From: Charlotte Easton
Sent: 24 April 2019 16:31
To: Planning Scanning
Subject: FW: WA/13/19/CLP - Midwood, West Walberton Lane, Walberton
Attachments: S1122 Midwood Planning Application 2 A2 (1).pdf

I write to you regarding WA/13/19/CLP – Midwood, West Walberton Lane, Walberton.

Proposed rear elevation
1:100

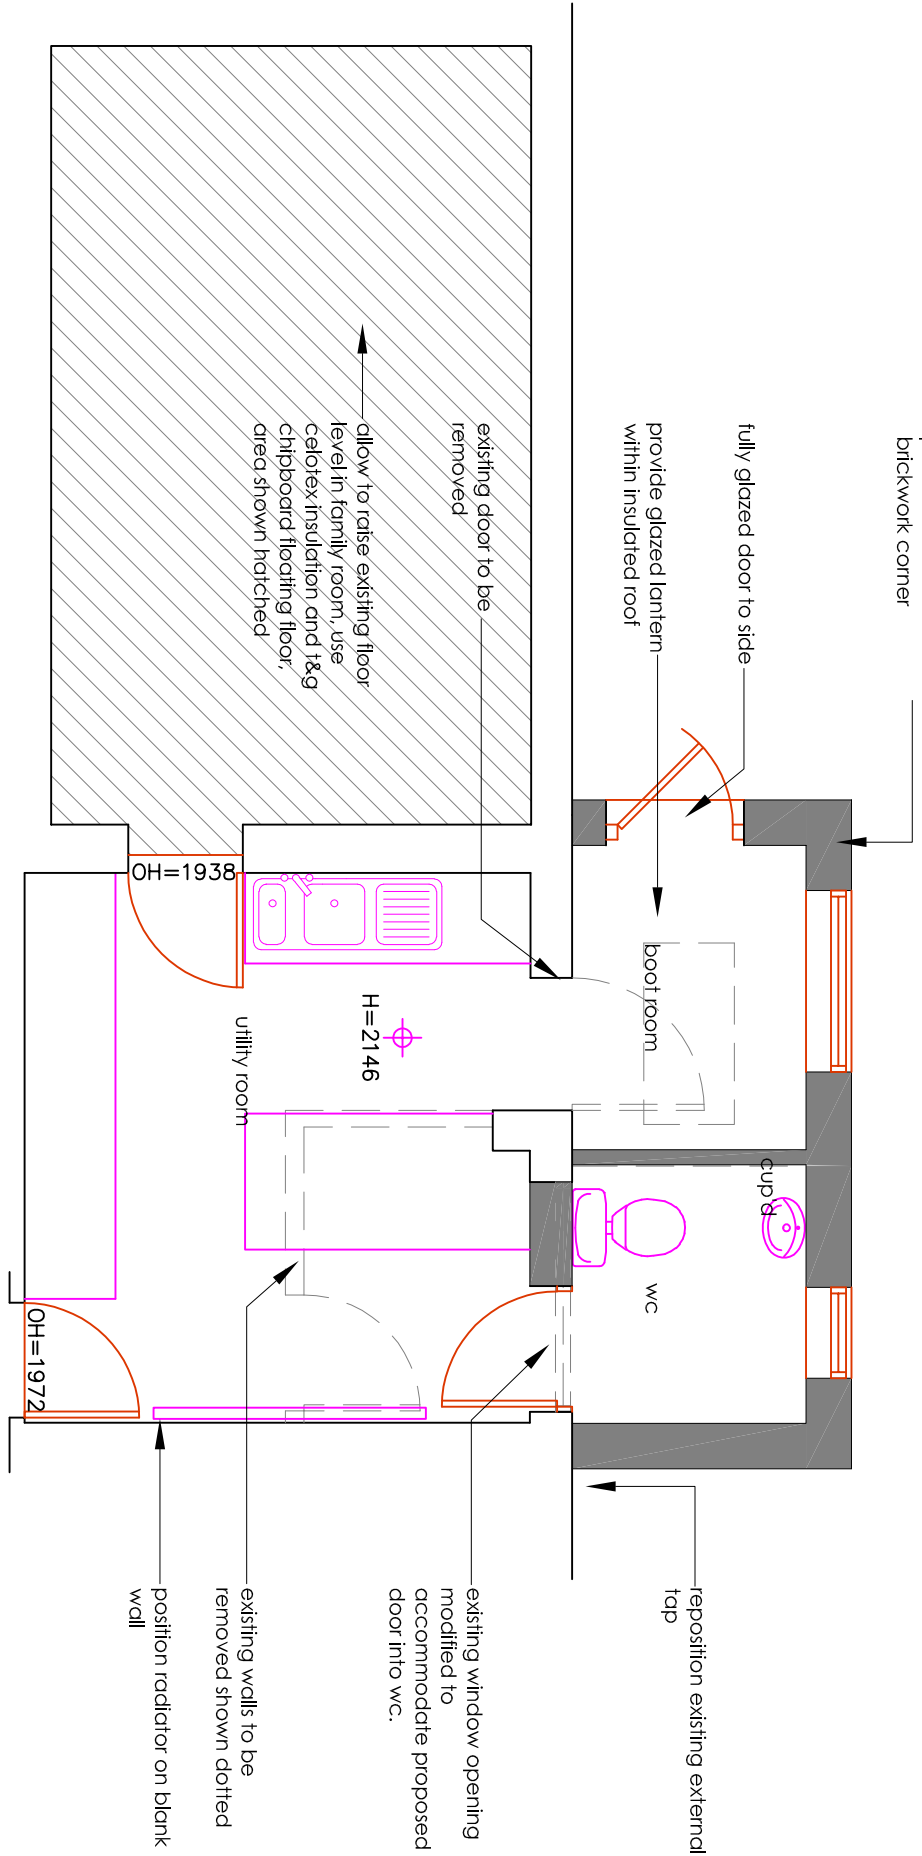
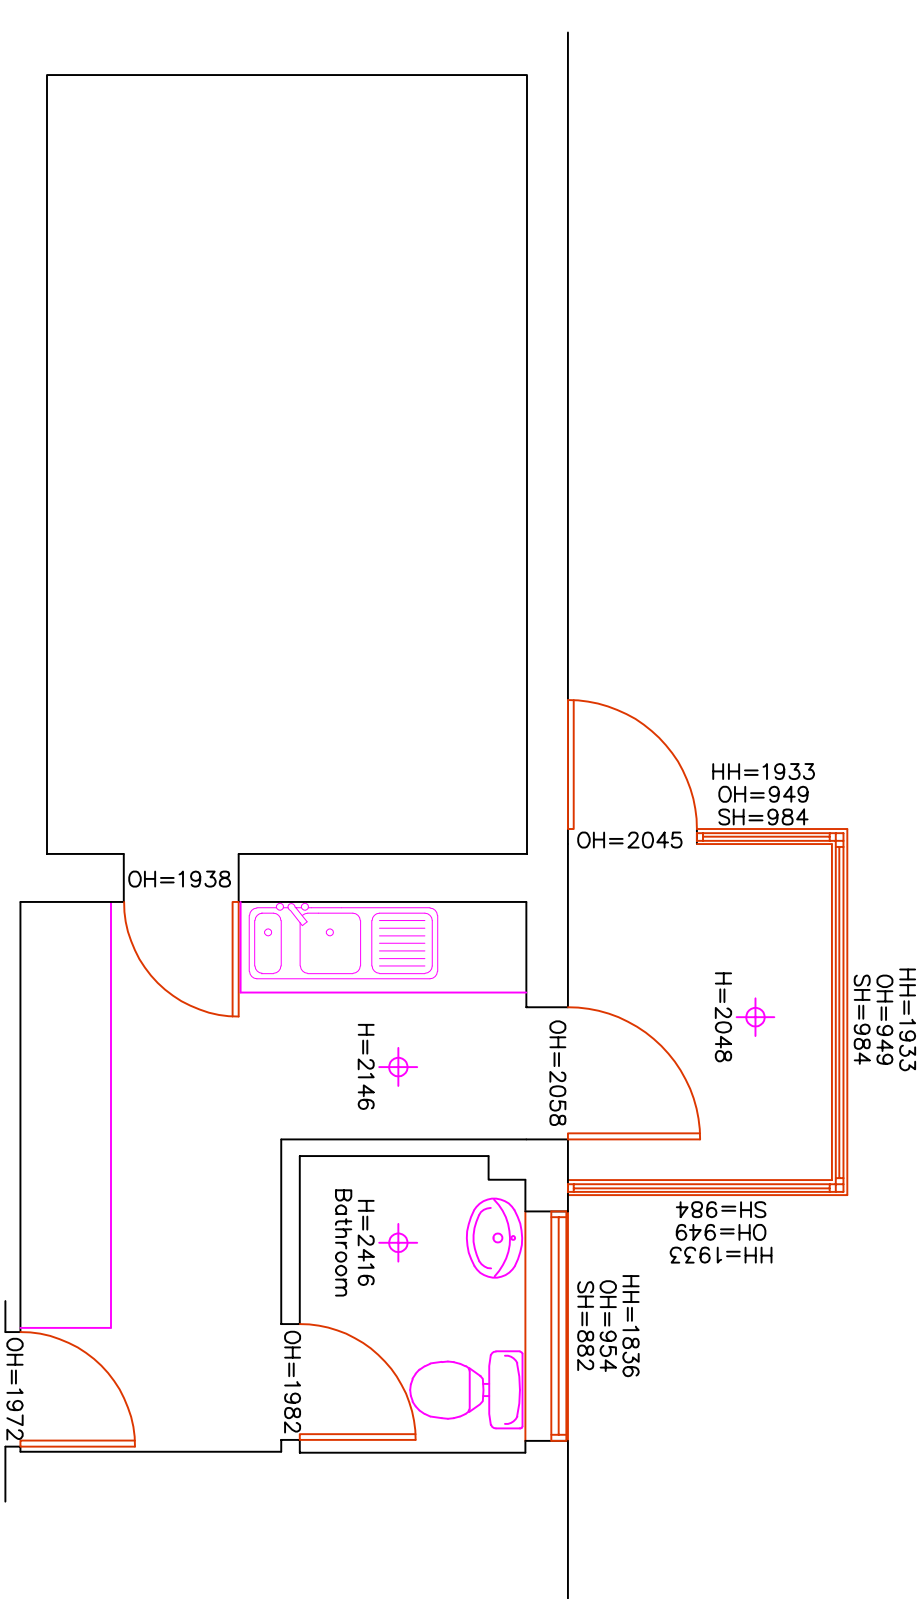
I am just in the process of writing the application up and have identified a potential issue. On the drawing Proposed Rear elevation the proposed eaves height of the rear extension appears to be higher than the existing eaves height of the original dwelling. As I am sure you aware, this would fail to comply with the General Permitted Development Order 2015 Schedule 2 Part 1 Class A, A.1 (d).

Please confirm if the plan submitted is correct or if there has been as error on the drawing.

That was an oversight on our behalf, please find attached the amended drawing.
Hopefully the application can now proceed to a positive outcome.
